Application No: EP/23/22/HH
Site Address: 5 Chiltern Close East Preston BN16 1RE
Description of works: Conversion of roofspace to habitable, including hip to gable enlargement and a rear dormer and front rooflight, single storey rear extension, and timber framed lean to porch to front.

Thank you for your internet representation made on 12th April 2022 which has been recorded as an objection with the comments as follows:

This council's Planning & Licensing Committee considered this Application at its meeting on 14th March.

ROOF PLAN, BLOCK
PLAN & LOCATION PLAN
AS PROPOSED

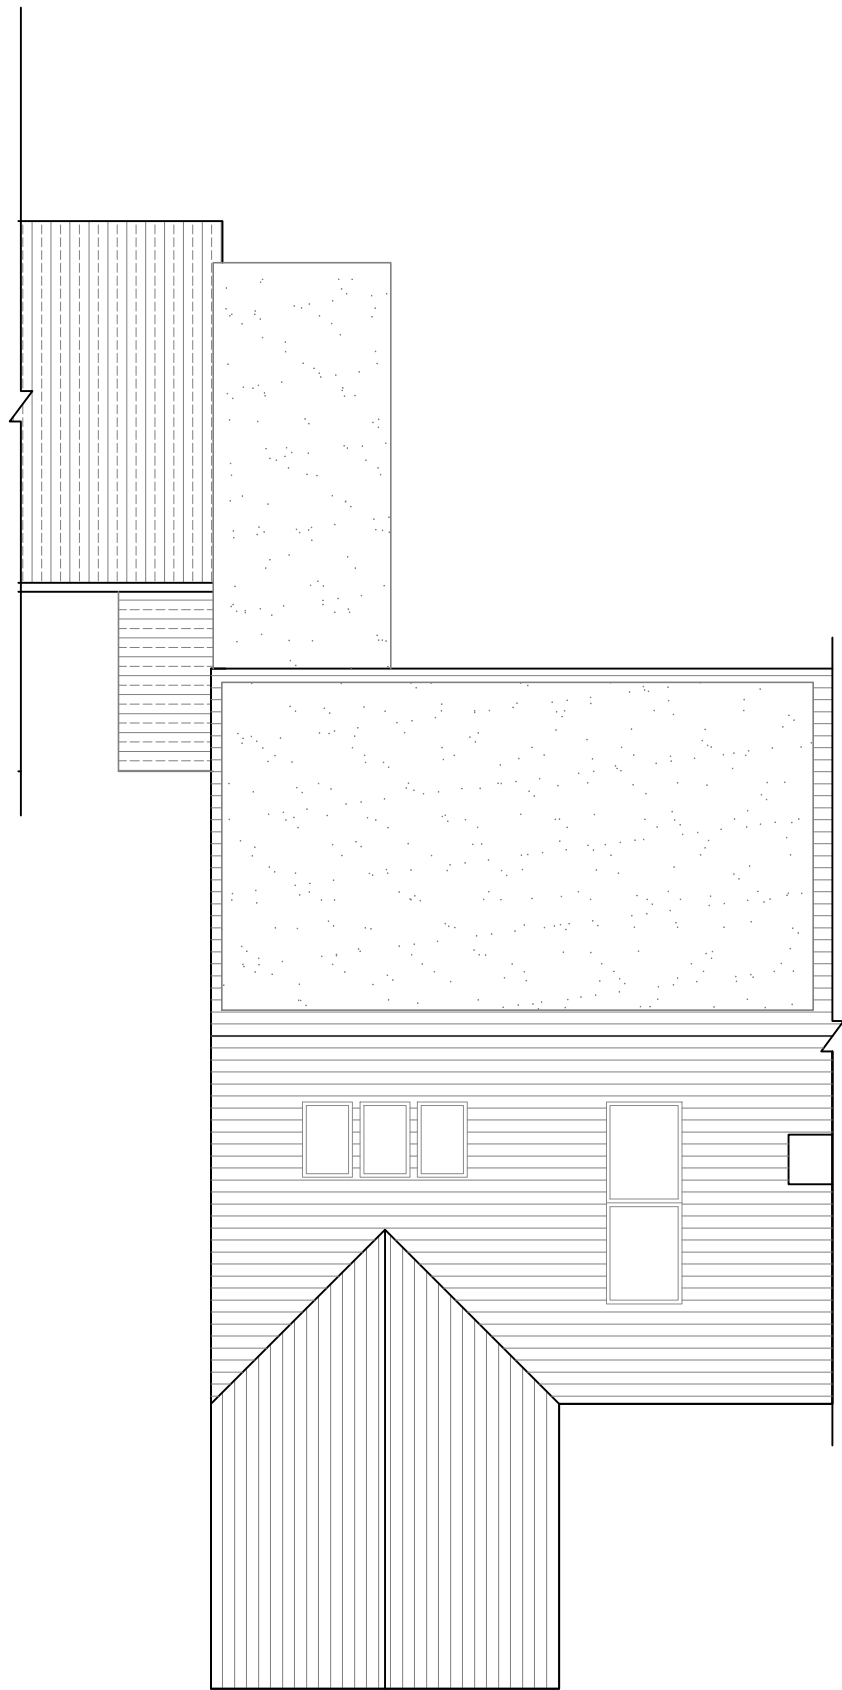
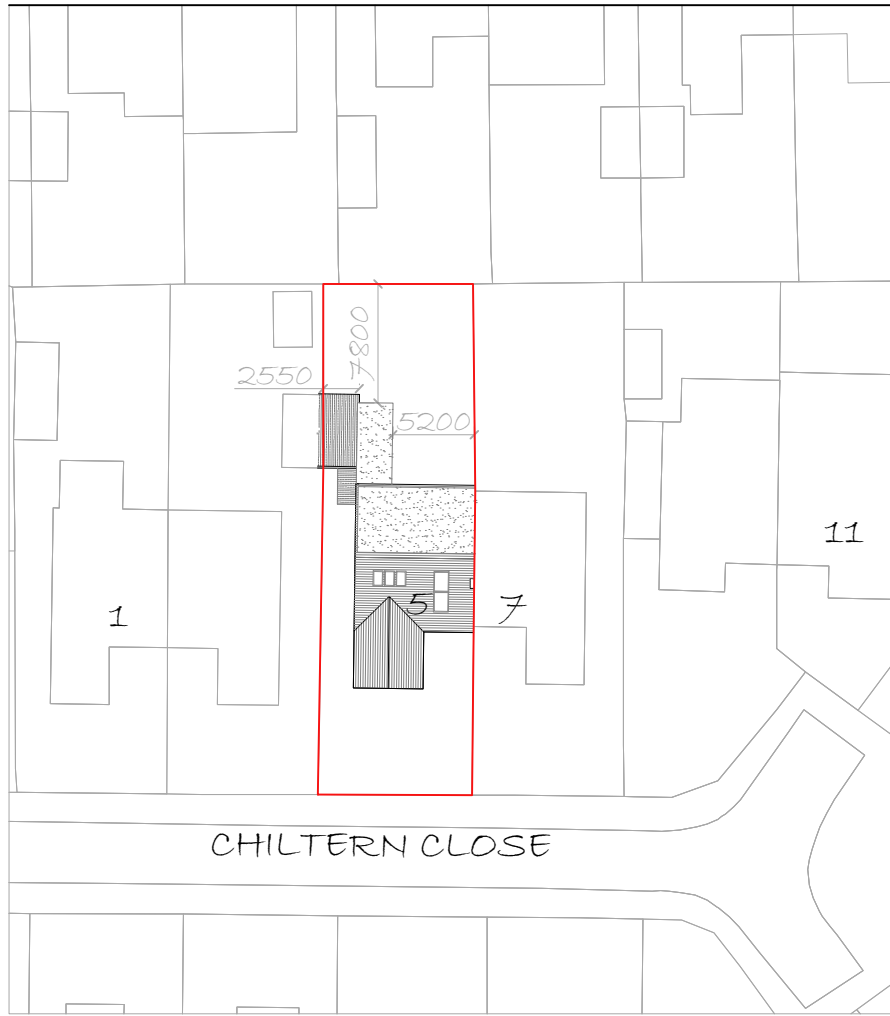
The East Preston Village Design Statement says dormer windows should be small enough to be subordinate to the appearance of the roof as a whole. The ridge of the dormer should be appreciably lower than that of the main roof, which is clearly not the case in this proposal.

GROUND FLOOR &
FIRST FLOOR PLAN
AS PROPOSED

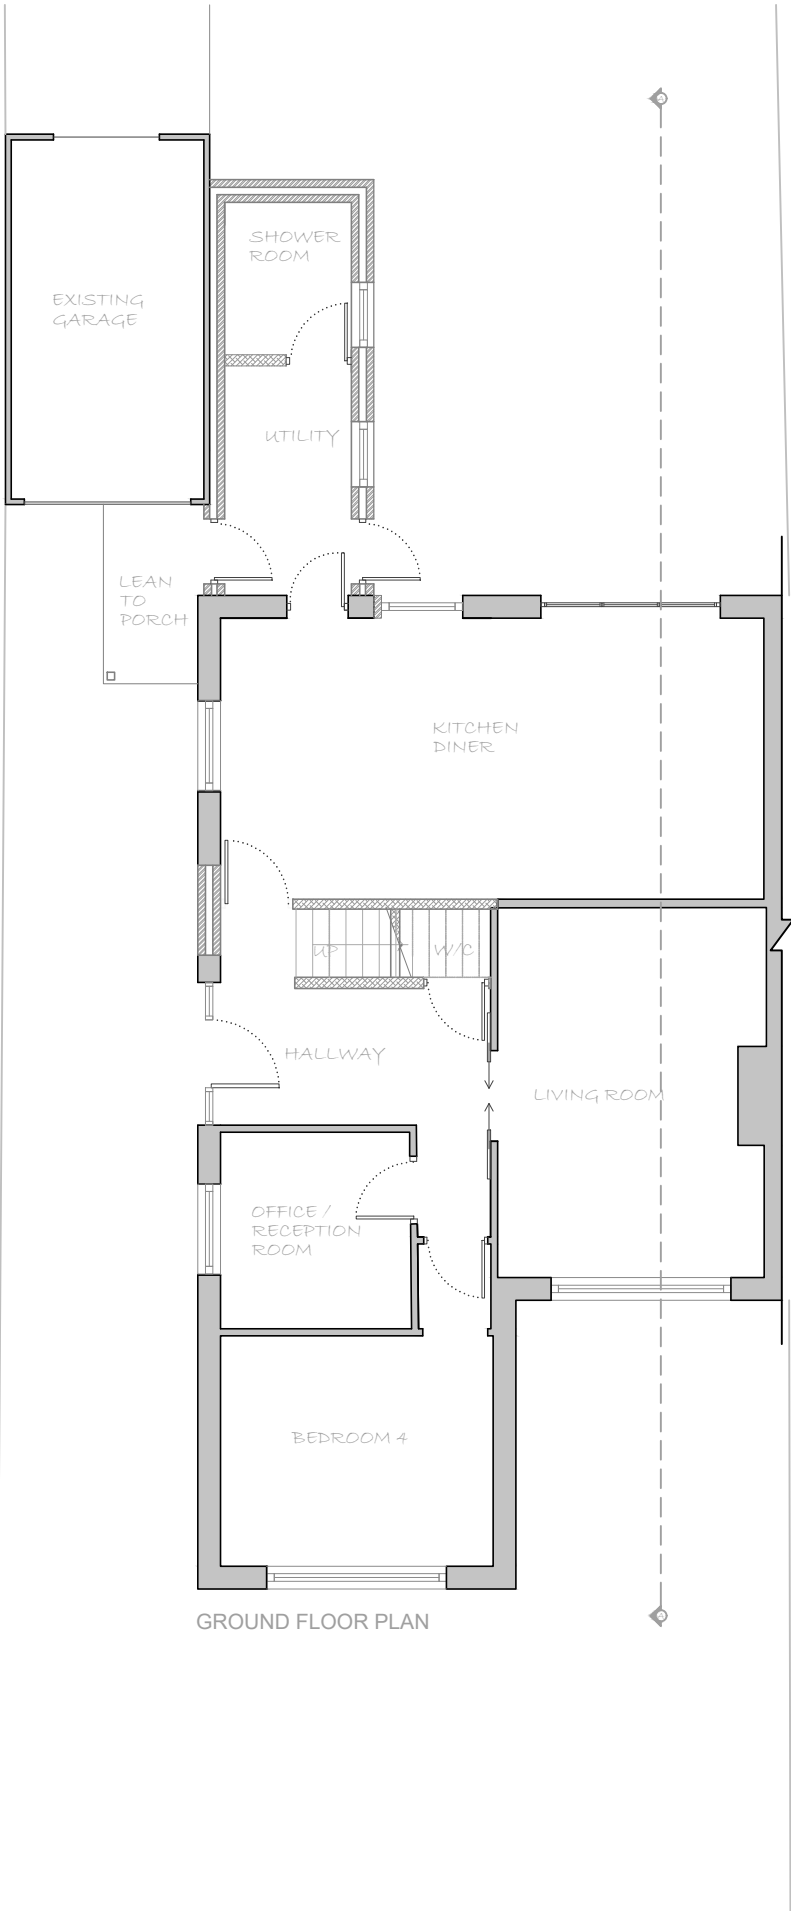
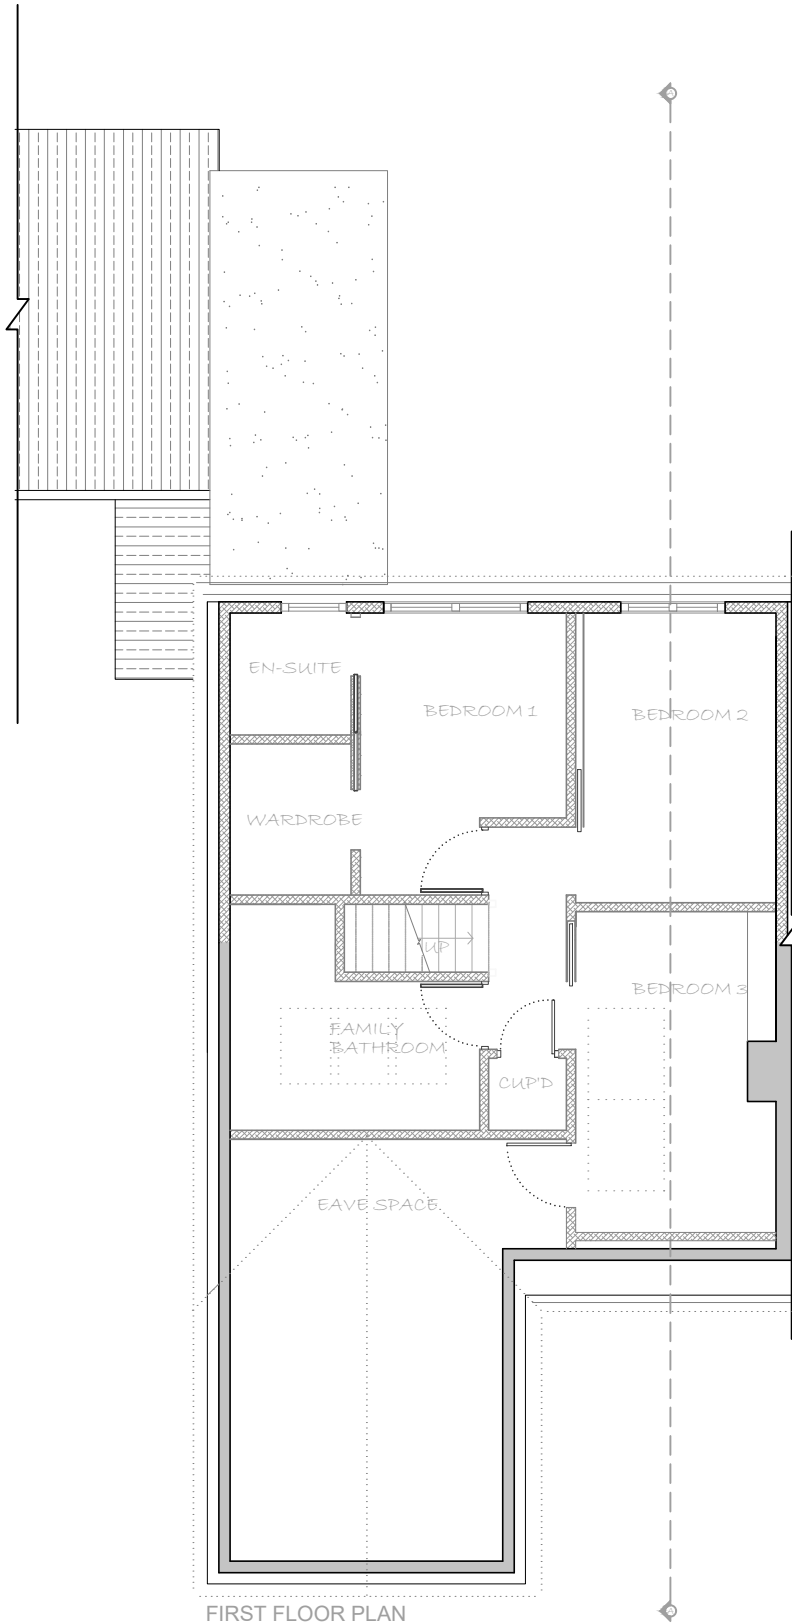
The committee was concerned at the appearance of a porch support which would make accessing the garage by car impossible. The committee also questioned the use of the phrase front rooflight for the fenestration proposed.

ELEVATION AND
SECTIONAL ELEVATION
AS PROPOSED

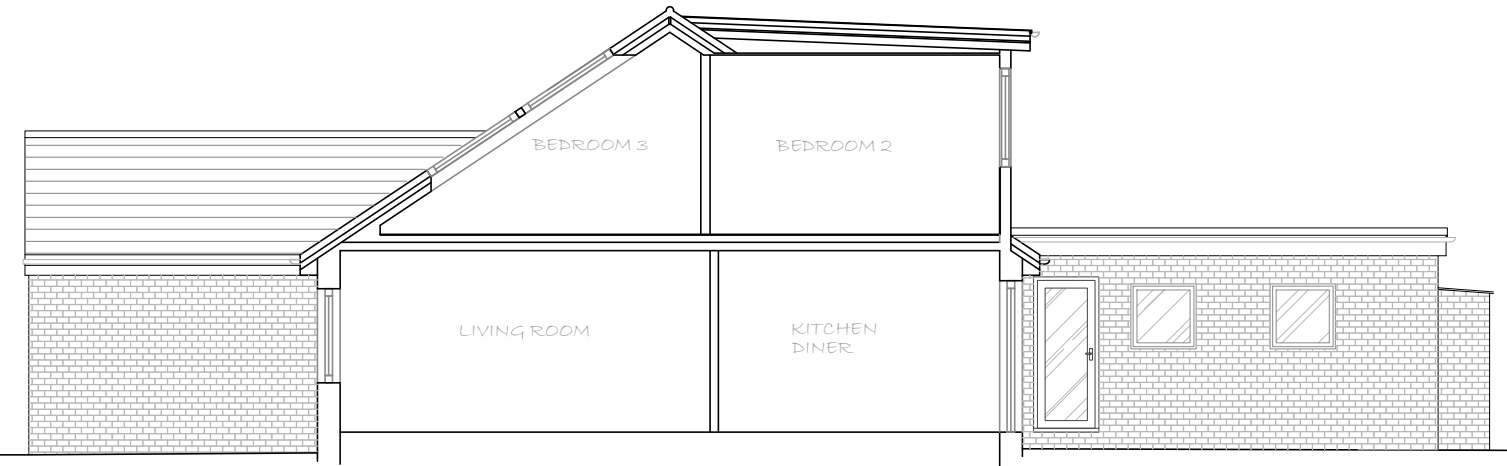
The committee agreed to object to this proposal on the grounds the property is half of a connected, matching pair, and this proposal risks unbalancing the pair.

Properties in Chiltern Close have mainly remained original and this proposal may also result in a negative impact on the streetscene, contrary to Policy 1: Housing General Principles, section 4.18 of the East Preston Neighbourhood Plan.
